Application for Removal or Variation of a Condition following Grant of Planning Permission or
Listed Building Consent

Number	<input type="text" value="322"/>
Suffix	<input type="text" value="A"/>
Property Name	<input type="text"/>
Address Line 1	<input type="text" value="St Albans Road"/>
Address Line 2	<input type="text"/>
Address Line 3	<input type="text" value="Hertfordshire"/>
Town/city	<input type="text" value="Watford"/>
Postcode	<input type="text" value="WD24 6PQ"/>

Erection of side and rear extension, alterations to existing elevations and change of use of rear part of ground floor to office (Use Class B1a)

Planning History 18/01188/FUL, then after application for external painted insulated render to gable/side elevation under 19/00223/VAR.
Revised drawings being PL-3000 REV B & PL-4000 REV B for 19/00223/VAR.

DATE	Aug 2018	DRAWN BY	K O'C
SCALE	1:50	REVISIONS	D
DRAWING NUMBER	PL-4000	A1 SIZE DRAWING	
Print Drawing at 1:50 for A1 size

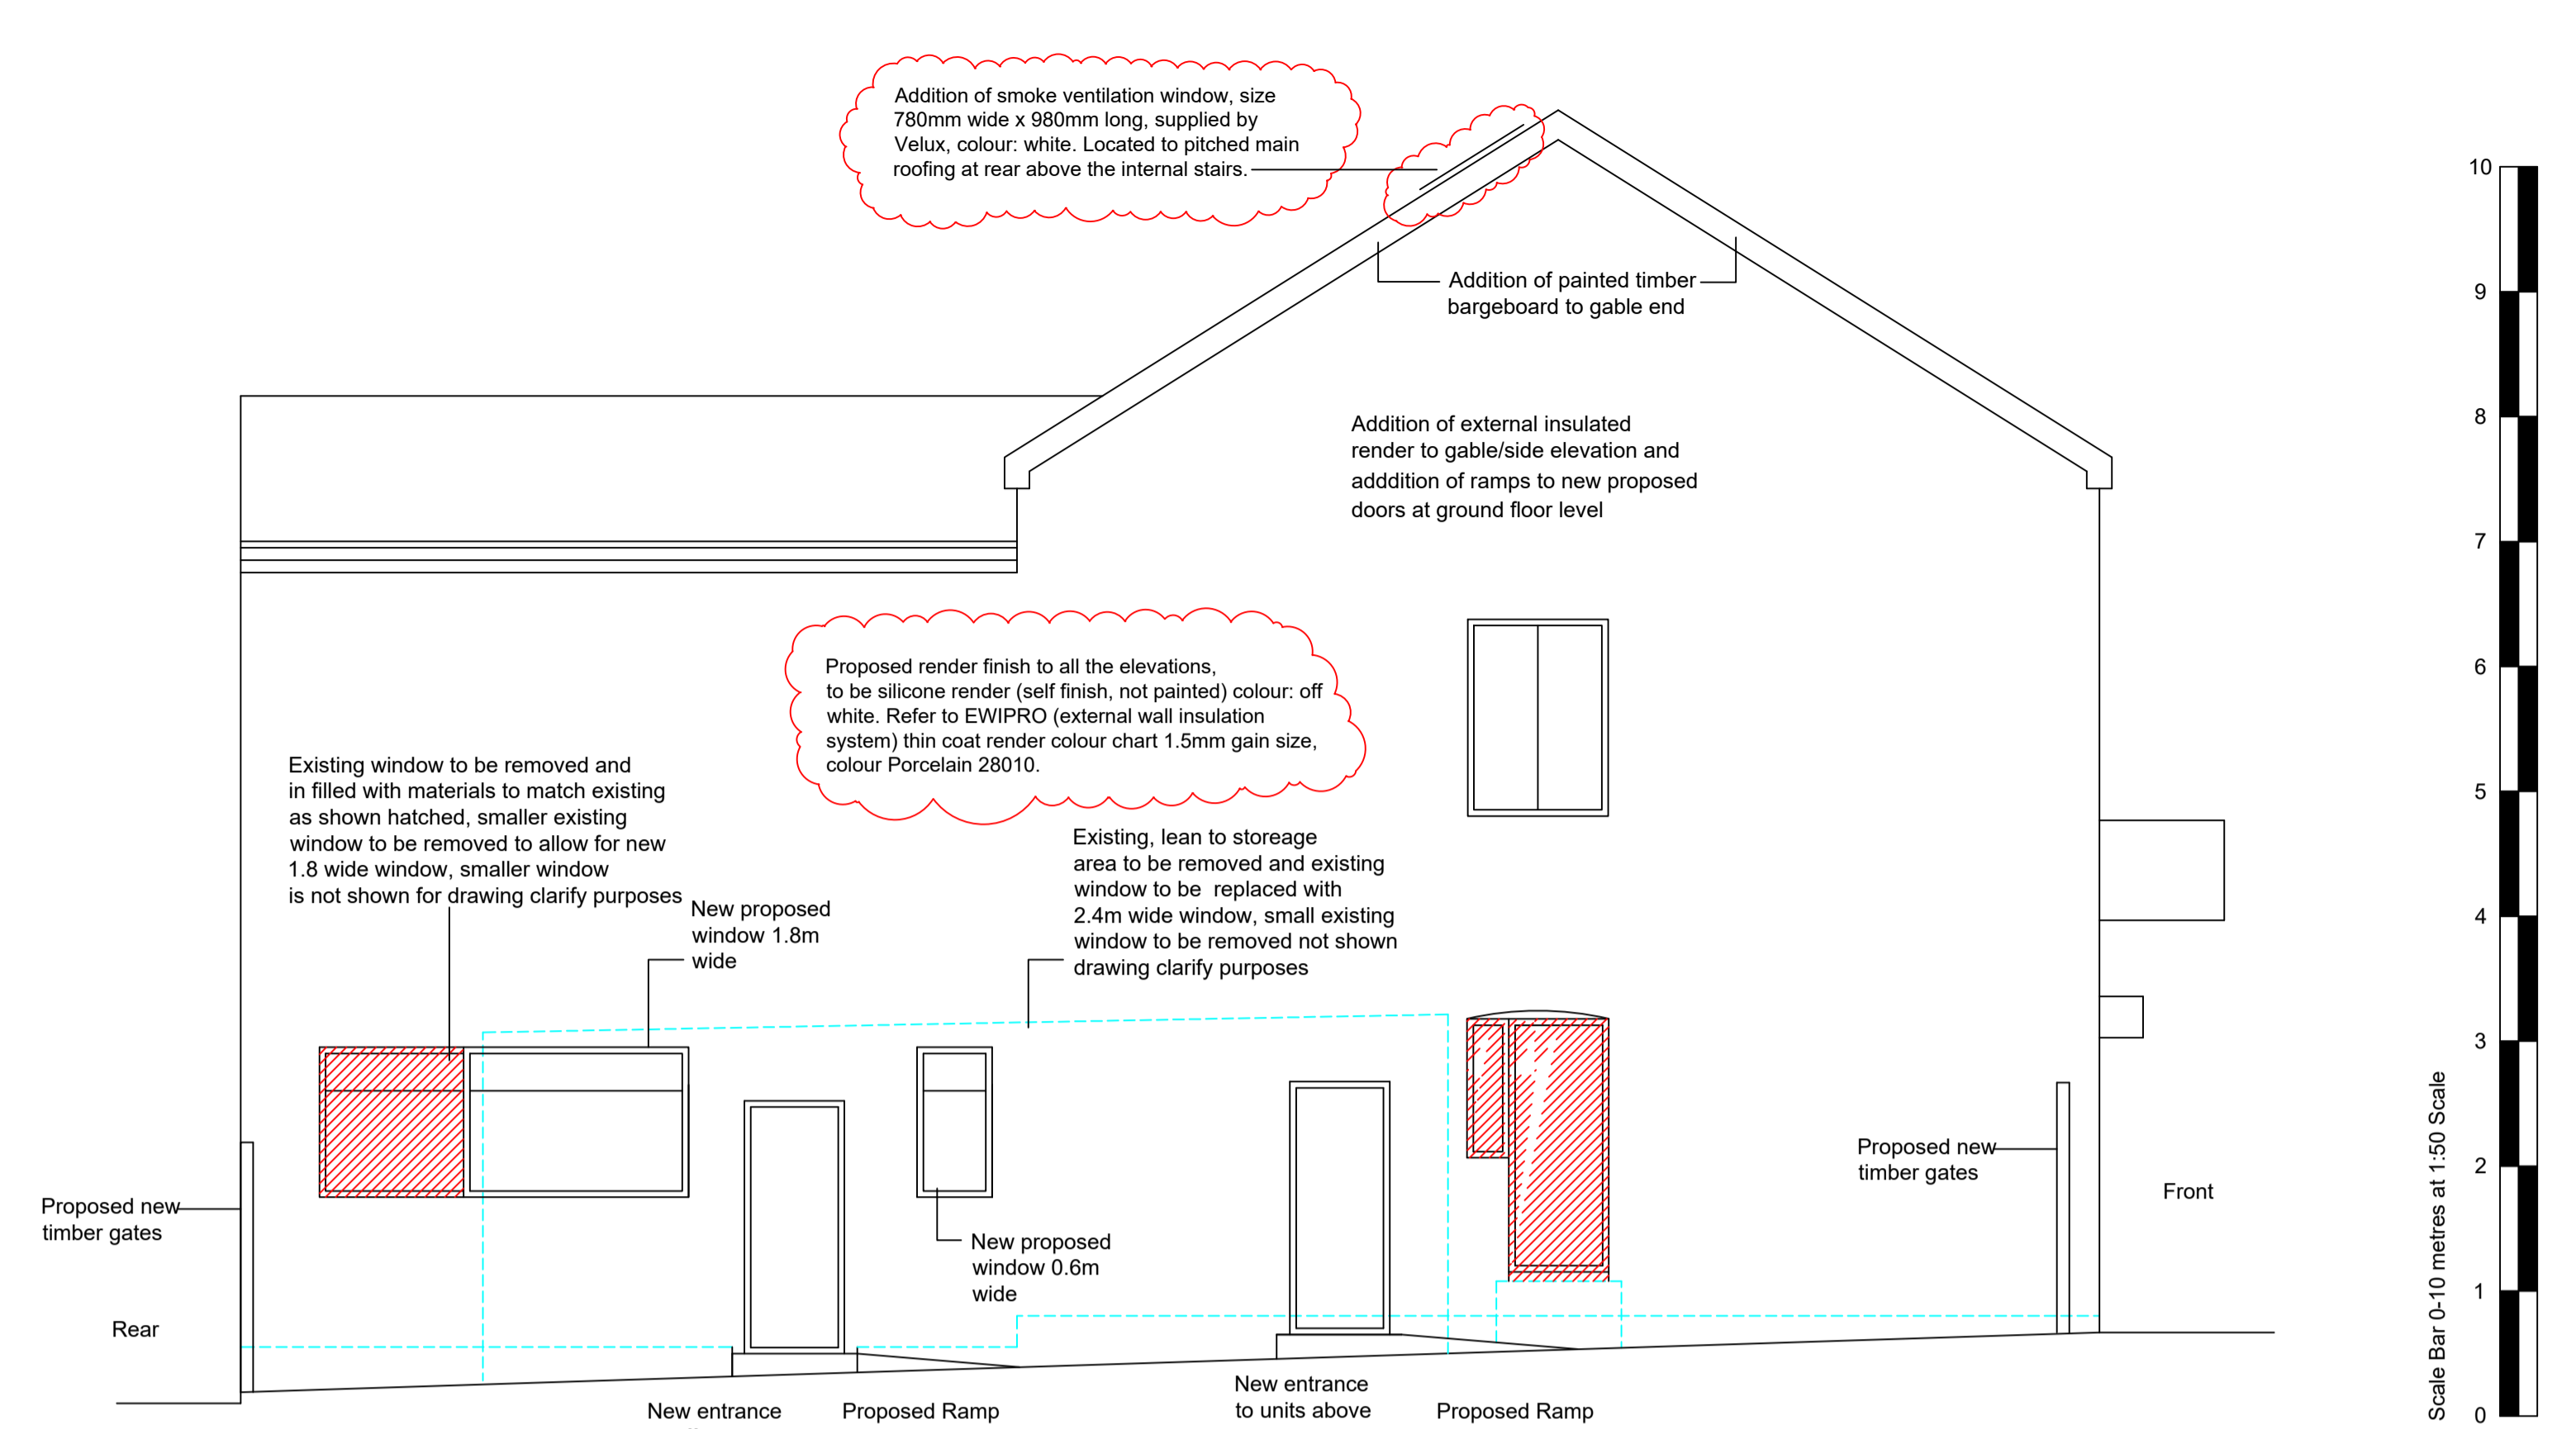
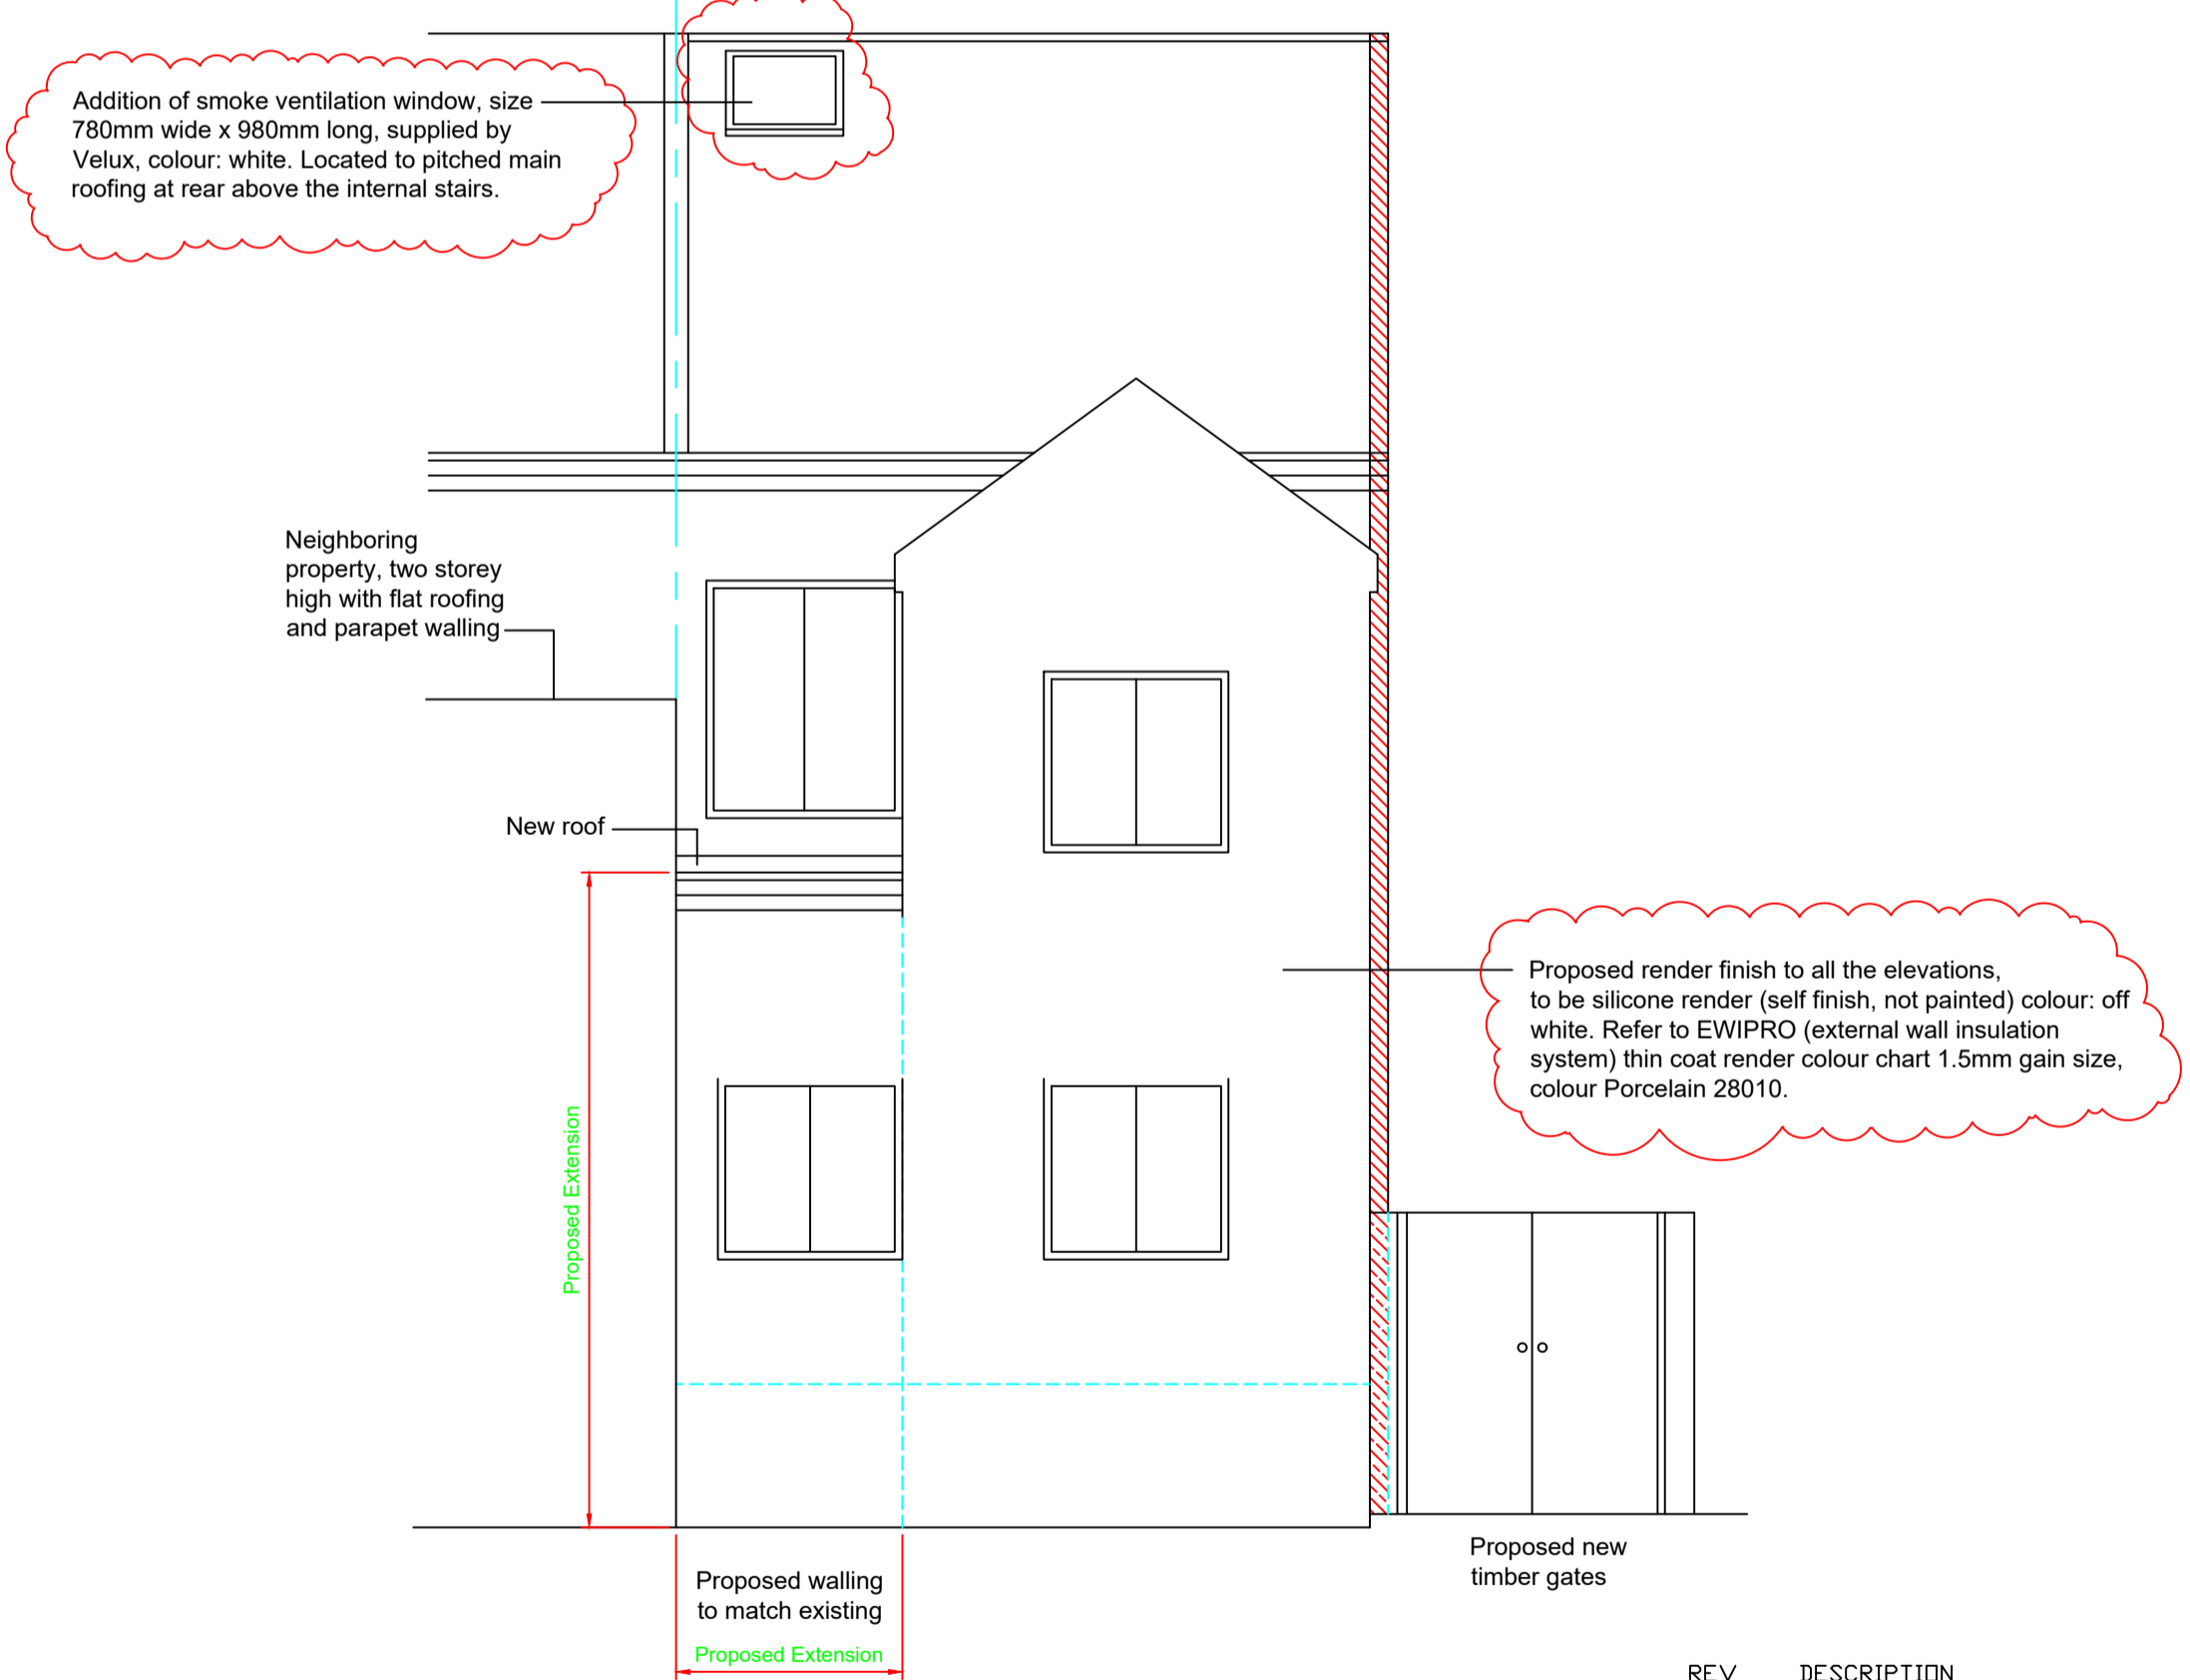
1/ Now this application is for another variation being addition of render finish to all the elevations being the rear, sides and front walls, also render type to be silicone render all the elevations (self finish, not painted) colour: off white. Refer to EWIPRO (external wall insulation system) thin coat render colour chart 1.5mm gain size, colour Porcelain 28010, refer to paper copy submitted and sample. Revised plans submitted PL-3000 REV D & PL-4000 REV D. Note that previous render to gable was painted finish, now silicone self finish Porcelain 28010.

1/ Note that proposed external finish is to match existing building, there would be no adverse effect on the character and appearance of the building or surrounding area.
